PLANNING CONSULTATION RESPONSE

Application No	2026/0306
Proposal	Variation of condition 2 to application 2025/0459 (Garage extension and boundary wall alterations) to allow for alterations to boundary wall design
Address	1 Poplar House Farm Close, Cudworth, Barnsley, S72 8FP
Date of Consultation Reply	07/07/26
Consultee	Highways DC

Proposed Front Elevation

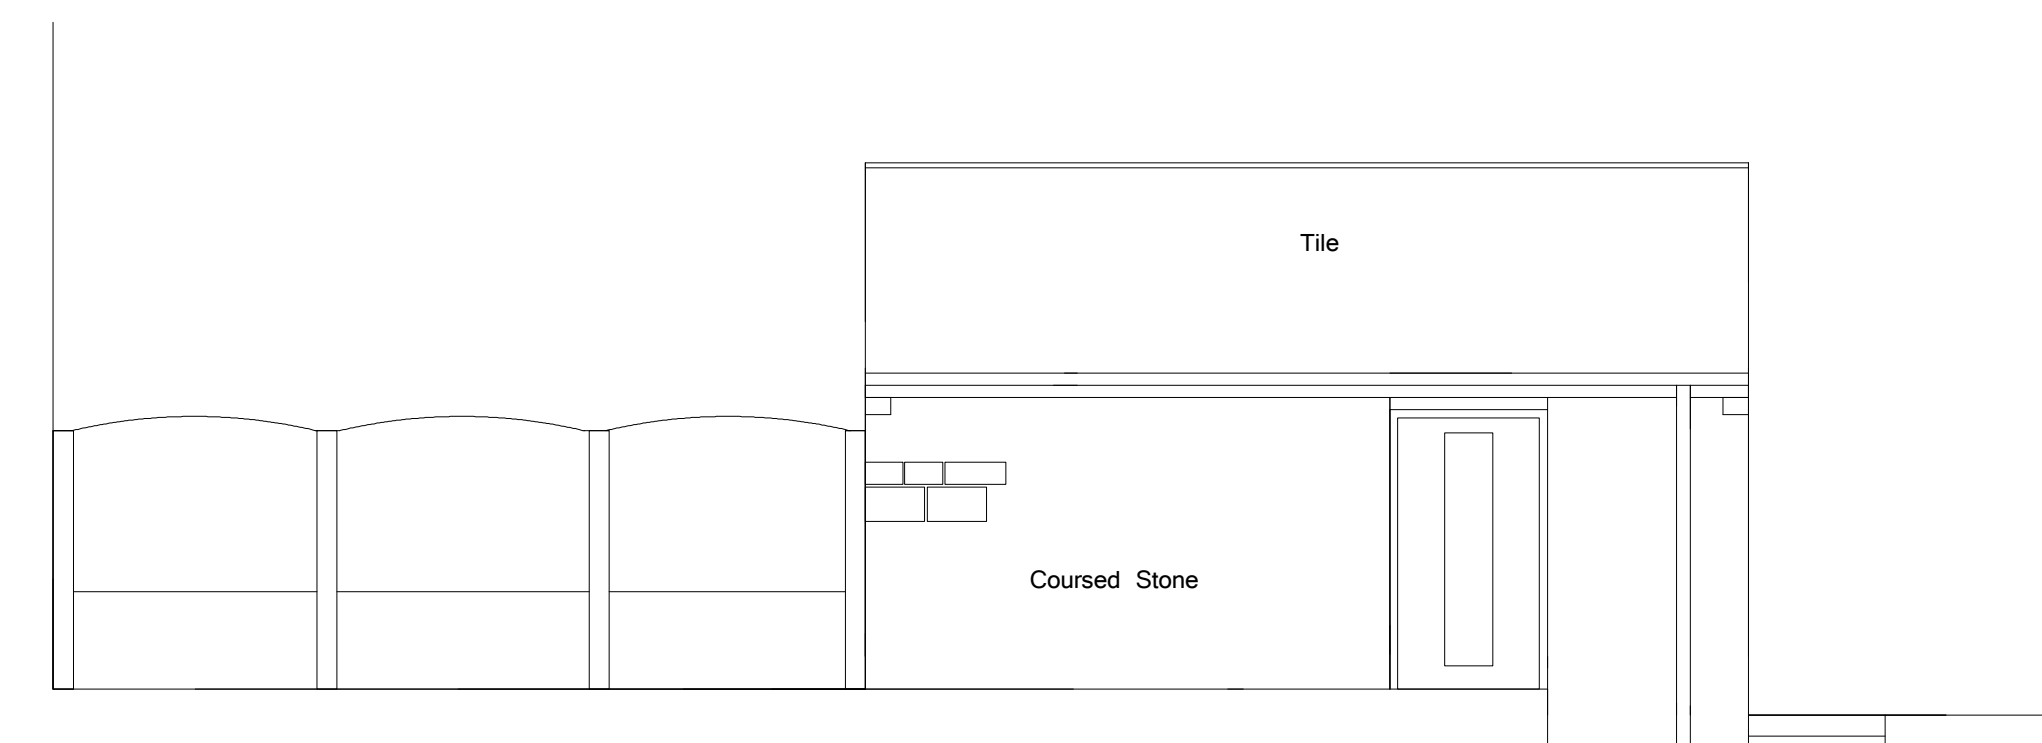
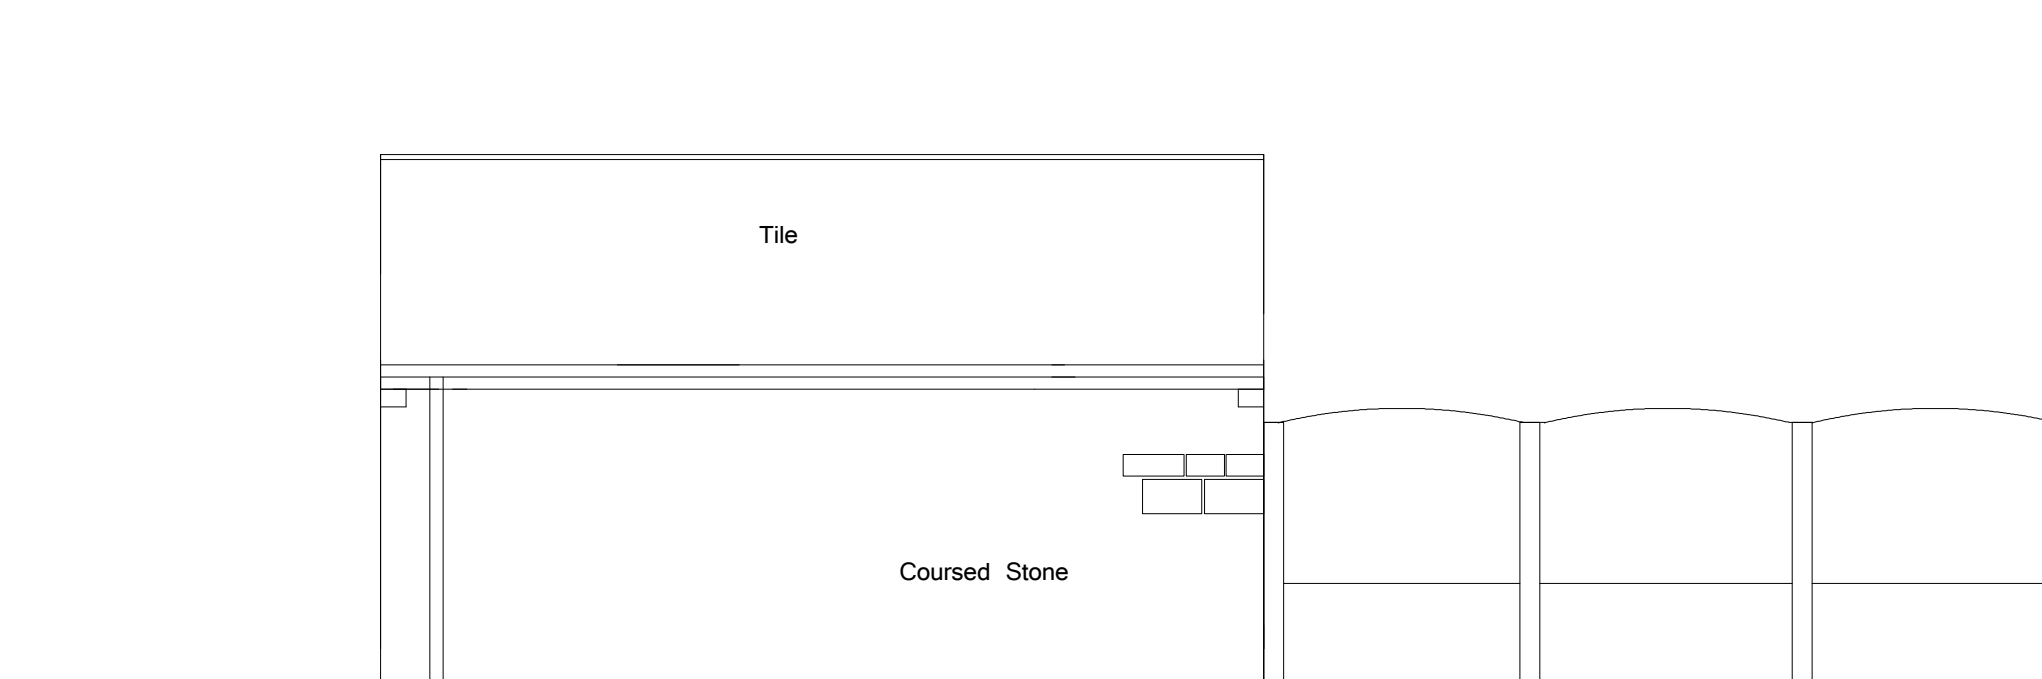
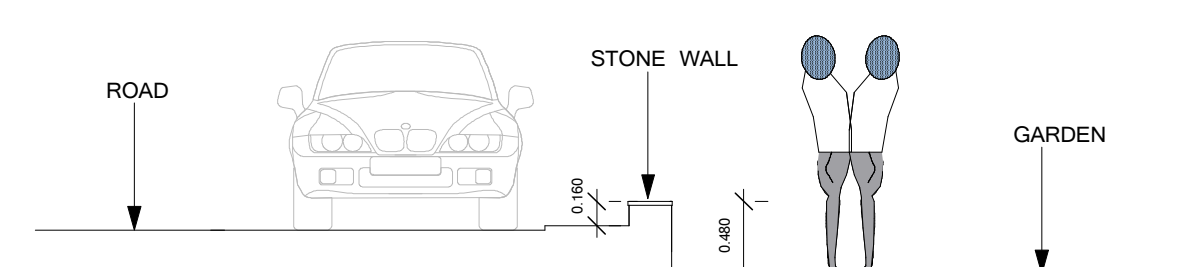
The proposed amendment would see the construction of a boundary wall raising 0.9m in height above the hard margin highway edge. Whilst the wall will be less than 1.0m above the carriageway, a section of fence will be above this height. However, visibility splays have been submitted that demonstrate this element will not impinge on the intervisibility between drivers and pedestrians.

The variation will therefore not impact on highway safety and HDC officers have no wish to raise objection to the application.
